Case Officer: Laura Bell

Applicant: Albion Land

Proposal: 1) Reconfigure the external layout of Unit 5; 2) Elevational changes to Unit 5; 3) Change the roof plan of Unit 5; 4) Elevational changes to Unit 6; 5) Change the roof plan of Unit 6; 6) Repositioning of Personnel Door of Unit 6 (proposed as non-material amendments to 22/01632/REM)

Drawing Title: ENTRANCE CANOPY DETAILS

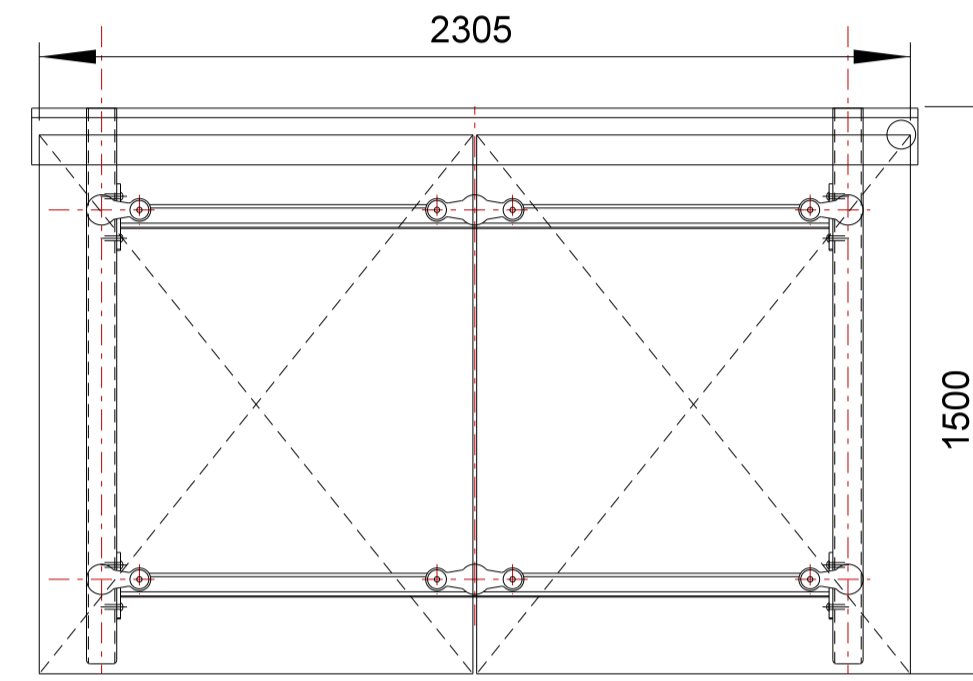
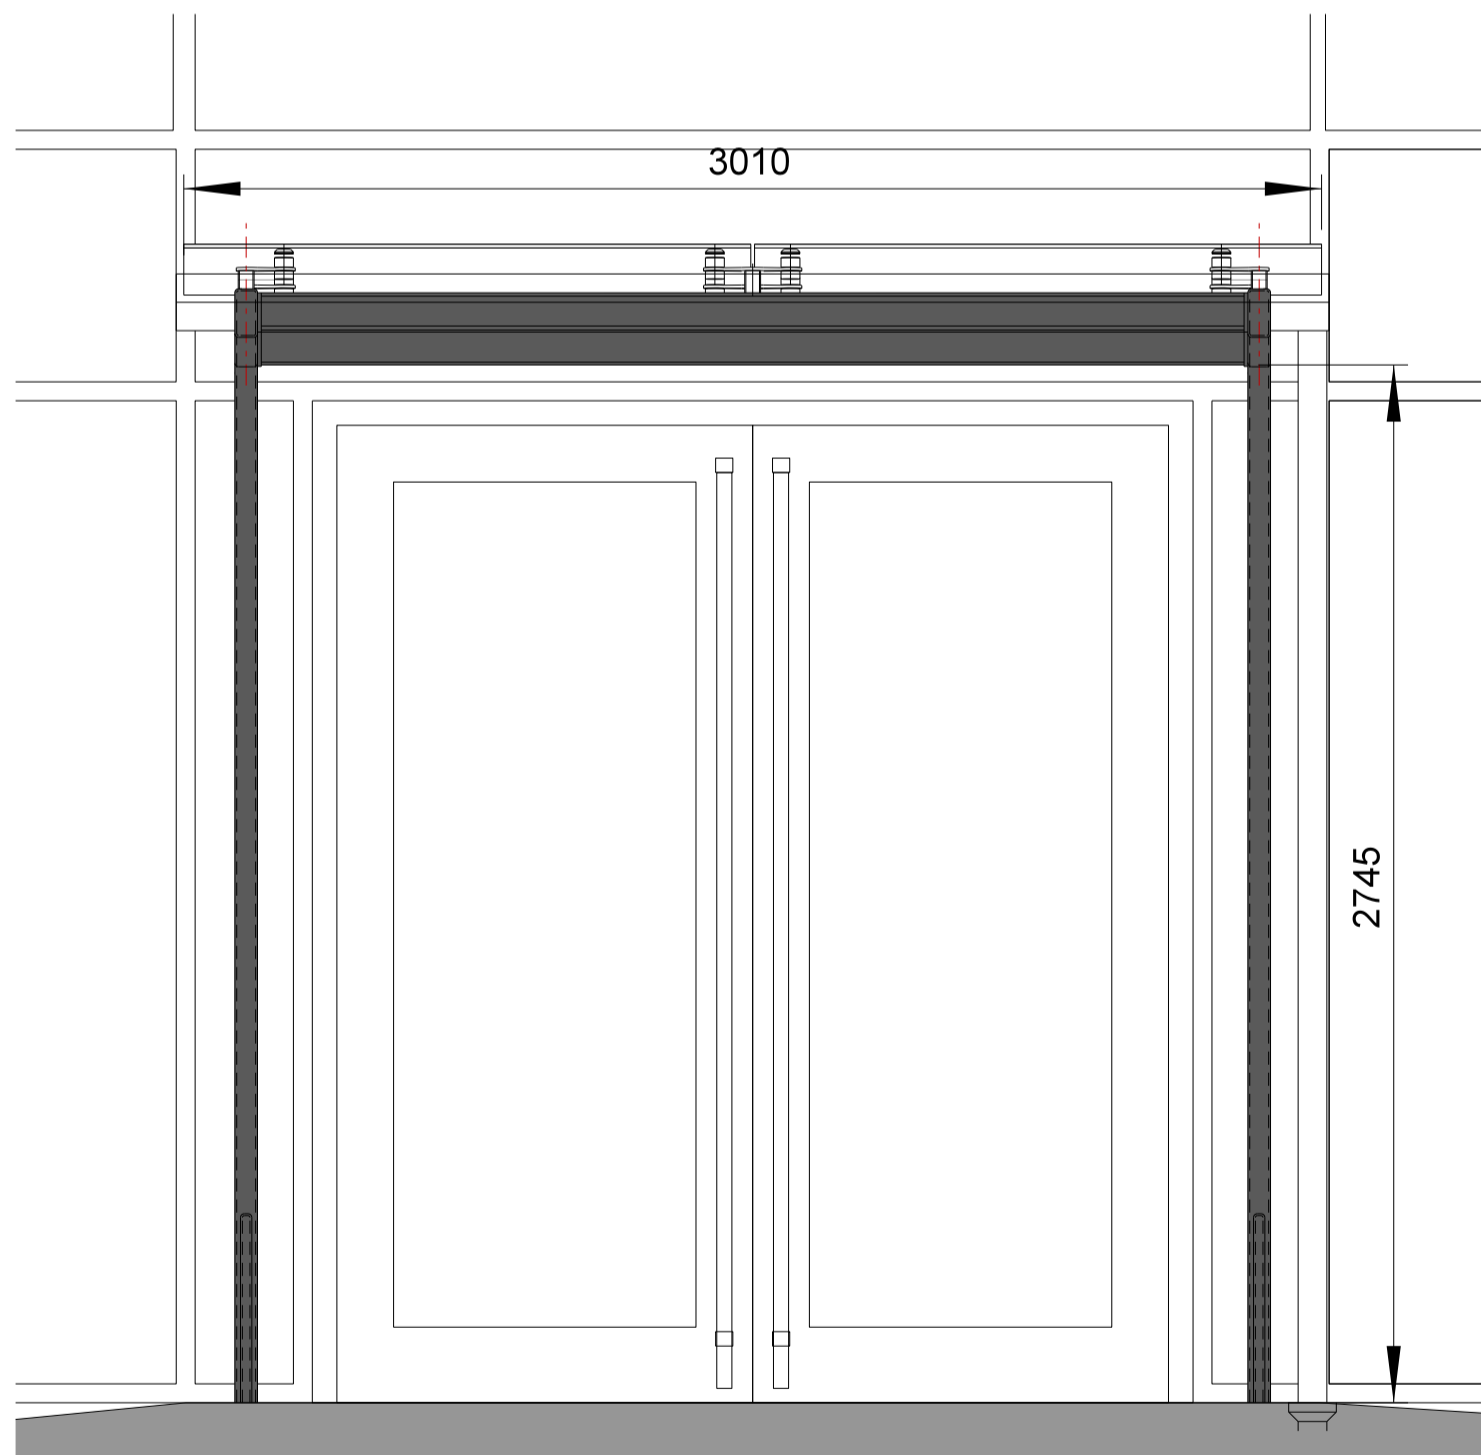
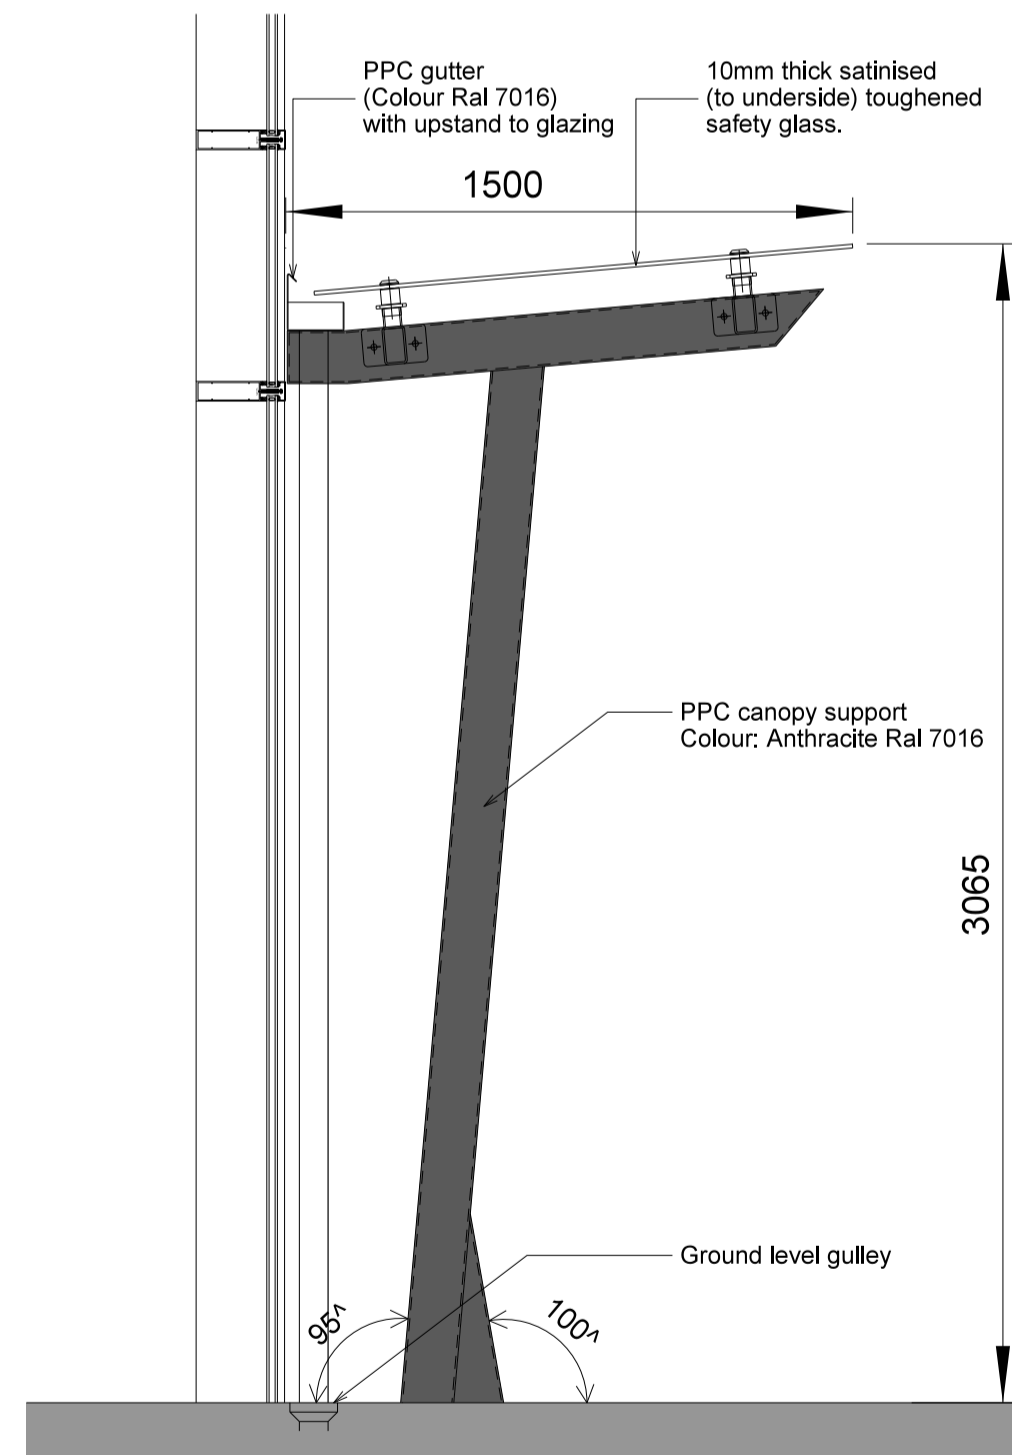
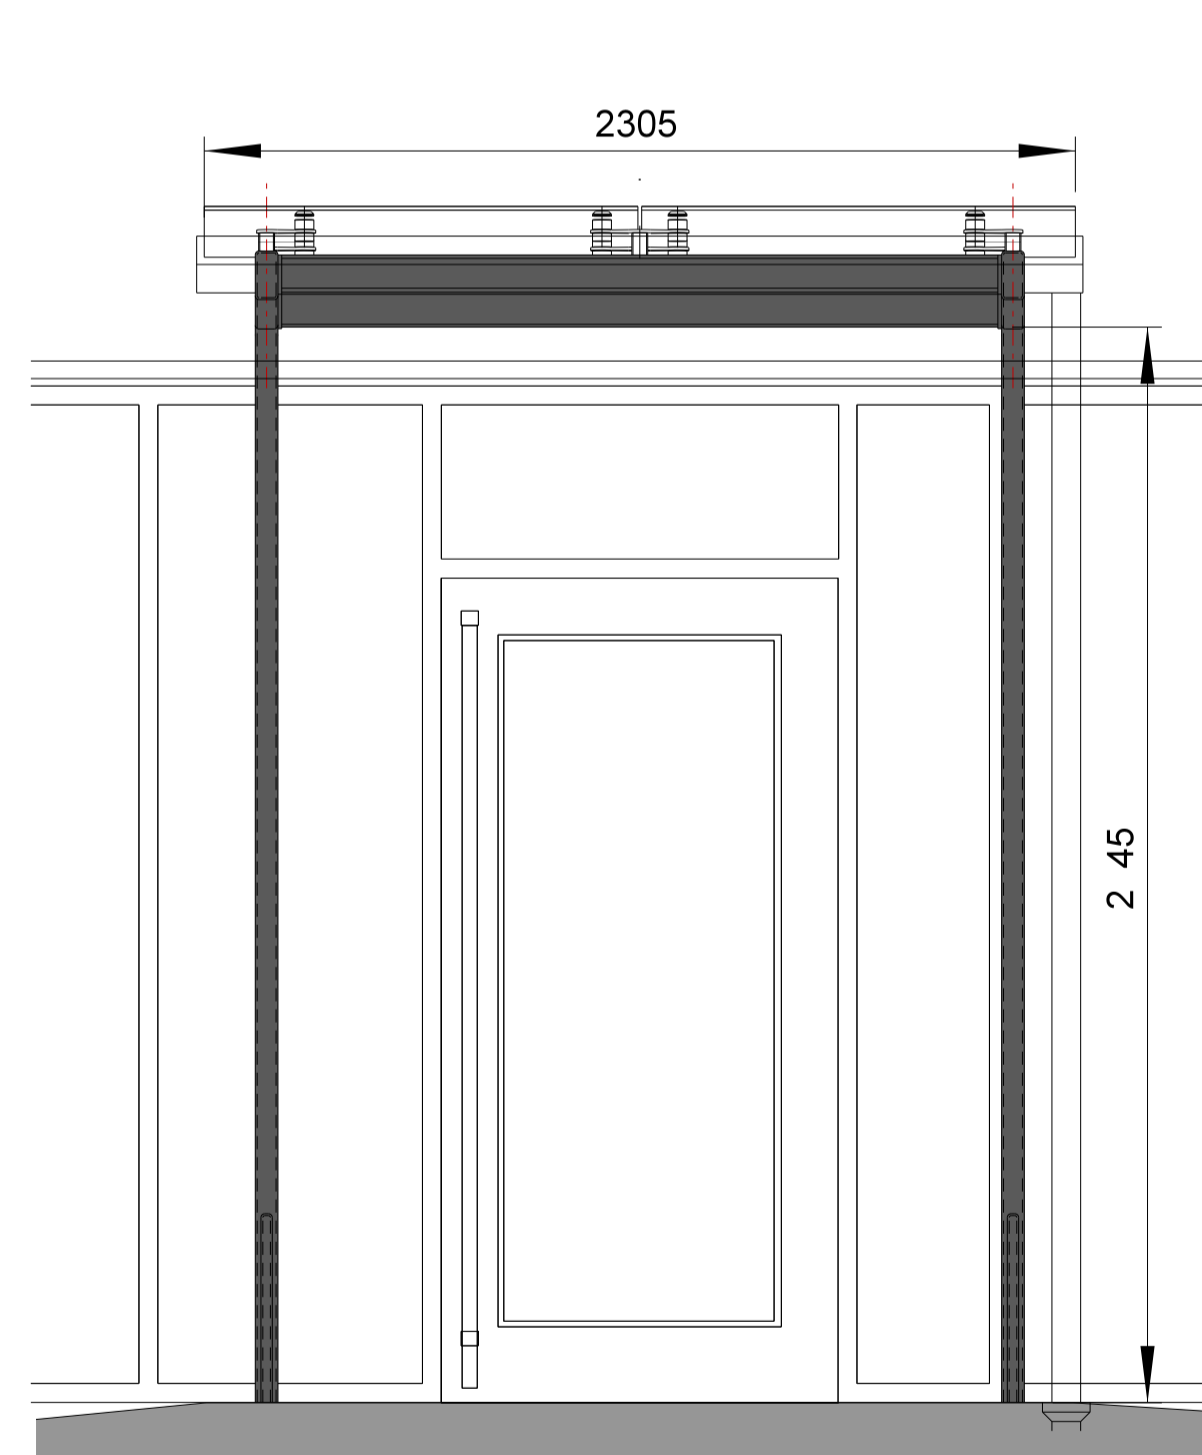
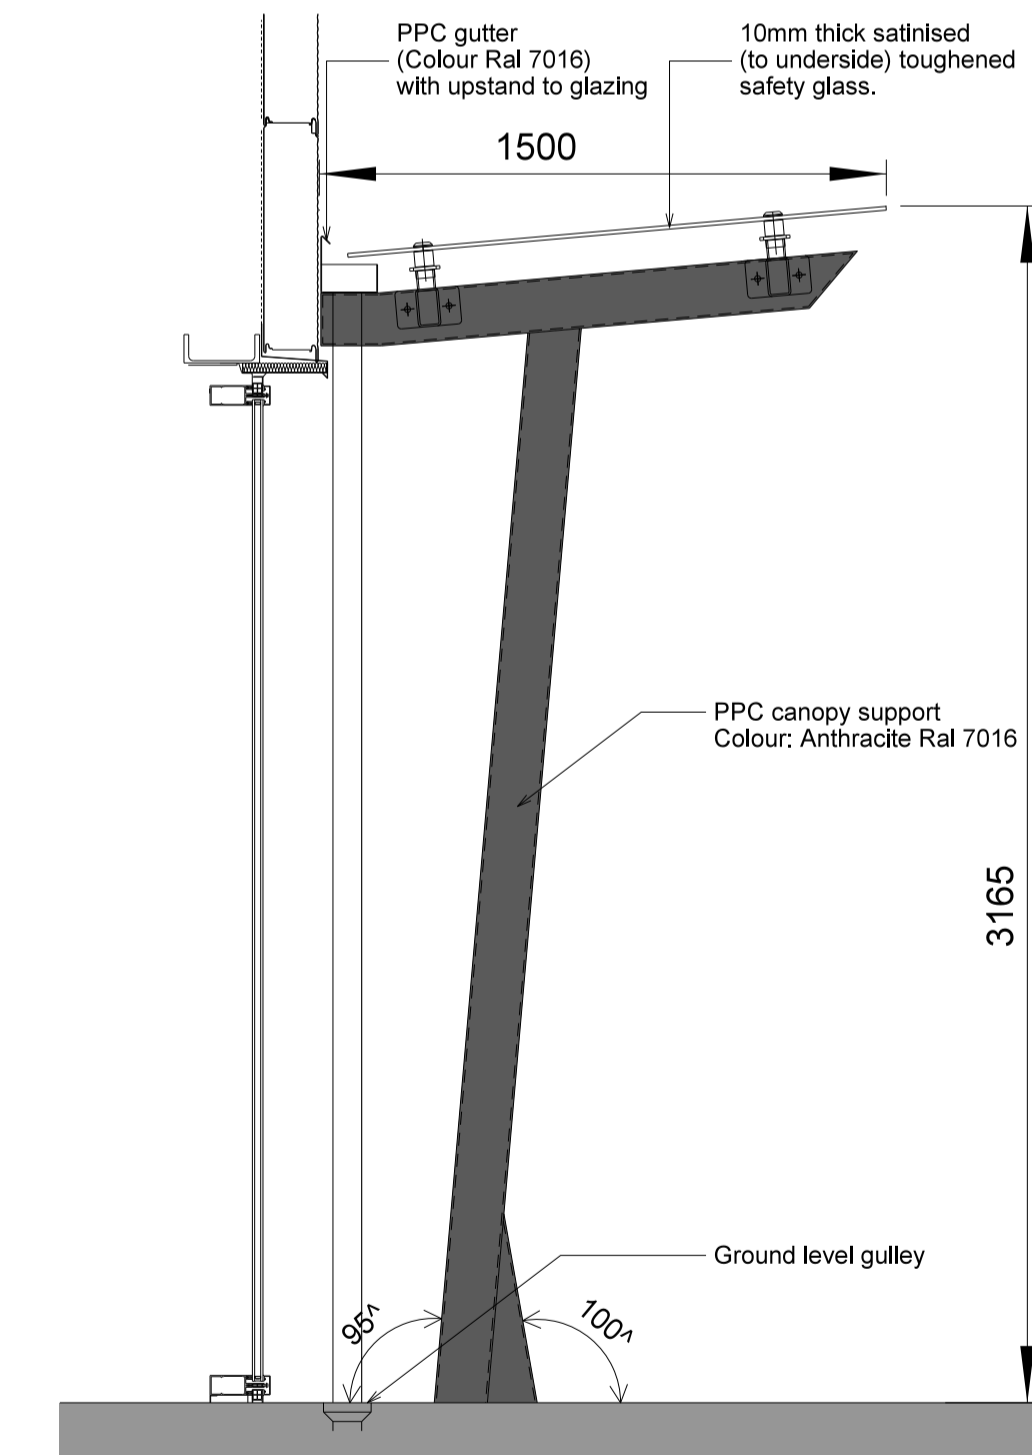
- 5.5. Elevational changes to unit 5 – The applicant states that the changes are in response to the requirements of the secured occupier of the site. Roller shutters have been relocated on the south east elevation, by spacing them further apart on the elevation, with the addition of an overnight delivery door. A sliding double door is also proposed on the south west elevation. Materials remain consistent with the style, form and character of the wider site. The changes are being sought by varying condition 1 to update the approved Entrance Canopy Details, Floor Plans and Elevations for Unit 5.
